Please could you upload the correspondence below and the attachments to the application folder BE/70/20/DOC as additional drainage information?

Subject: RE: RE: BE/70/20/DOC Drainage Planning Comments [Filed 20 Aug 2020 08:10]

Condition 6- surface water drainage design

PHASE 1A - LIDL SITE
DRAINAGE LAYOUT

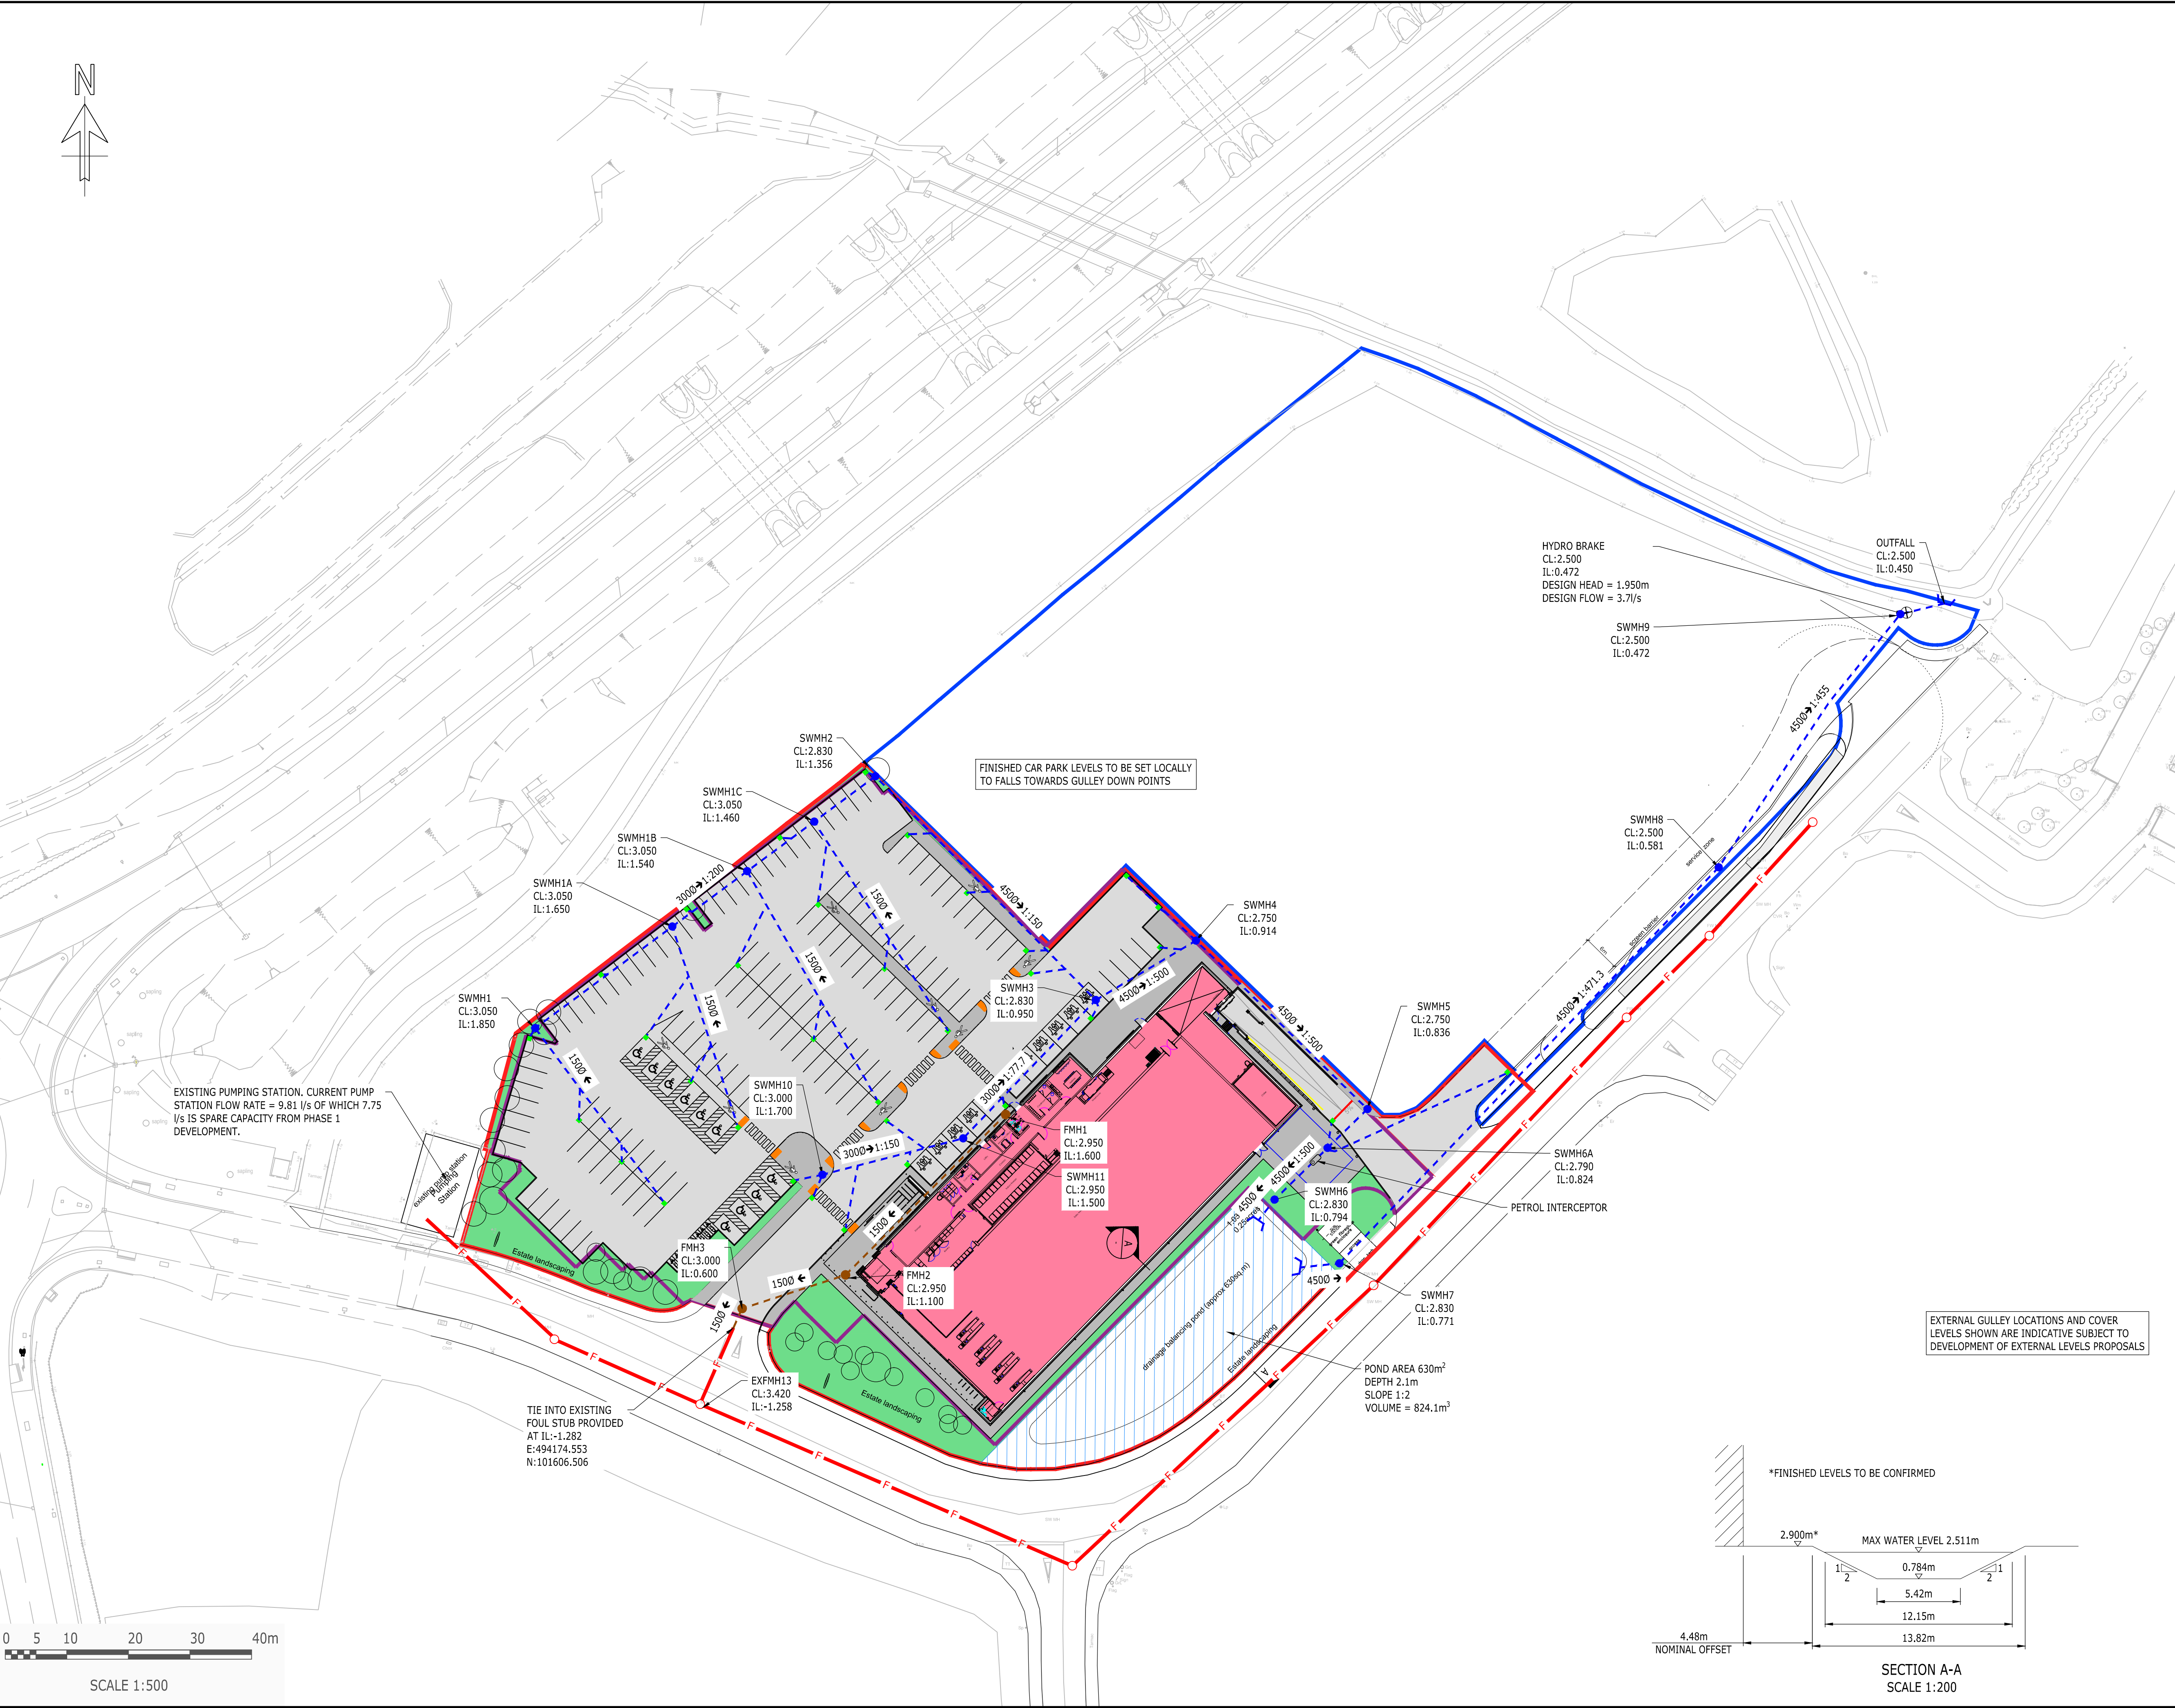
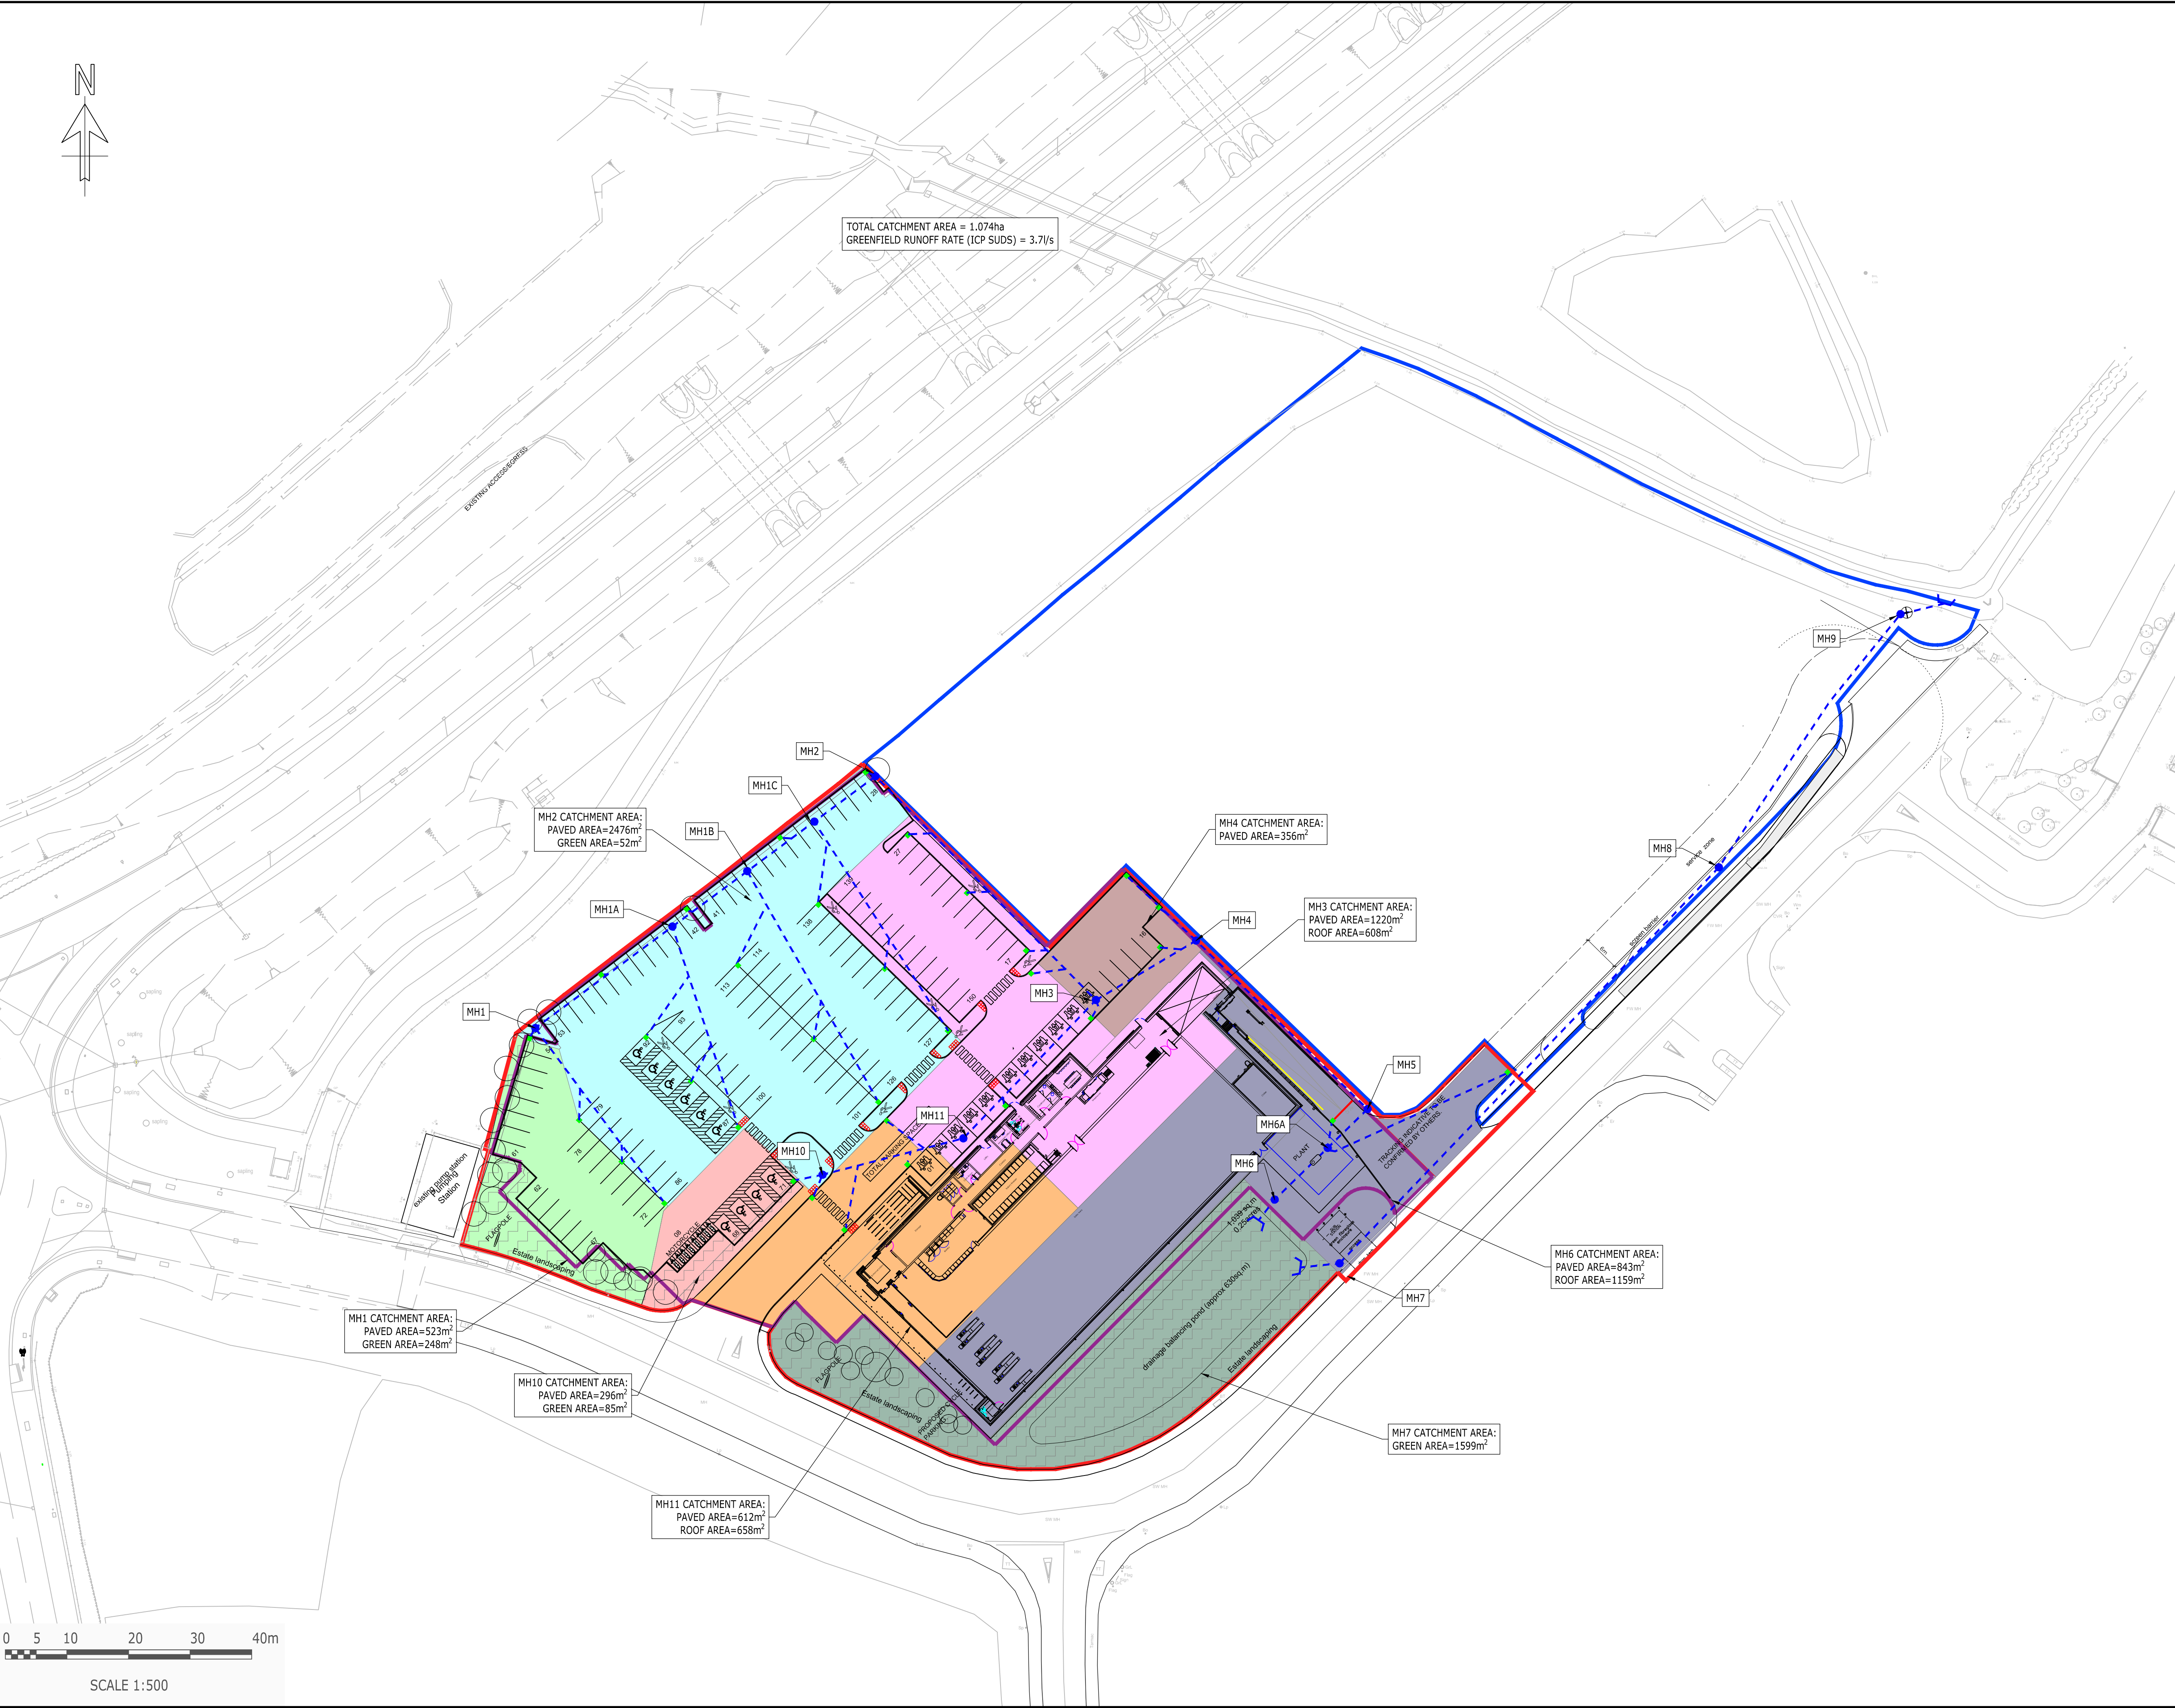
4. We note that MicroDrainage has been set to autodesign pipes to achieve 0.75m/s, 1 m/s must be achieved. Please include a printout from MicroDrainage indicating velocities achieved in pipes. *As per point 2 original design submitted and reviewed was set to 0.75m/s and was not requested to be increased to 1m/s as part of the comments raised by David. We are working to fairly constrained site levels and as such do not believe this is achievable in the current system. The maintenance schedule provided will ensure these pipes are cleansed accordingly in any case. Pipes must achieve 1m/s, we note that the majority of pipes are achieving circa 0.9m/s as per MicroDrainage printout. Please review design.*

We will review the pipe falls and increase as best we can to achieve 1m/s. Note, we currently have 250mm freeboard above the ditch connection point this will likely reduce in order to increase velocities. However, it is noted minimum freeboard of 100mm will still be required as per previous ADC comments. This may also result in more storage being required due to the velocity at which flow moves through the network. This will also be achieved through additional cellular storage provided upstream with appropriate flow controls (orifice or similar). Plans awaited.
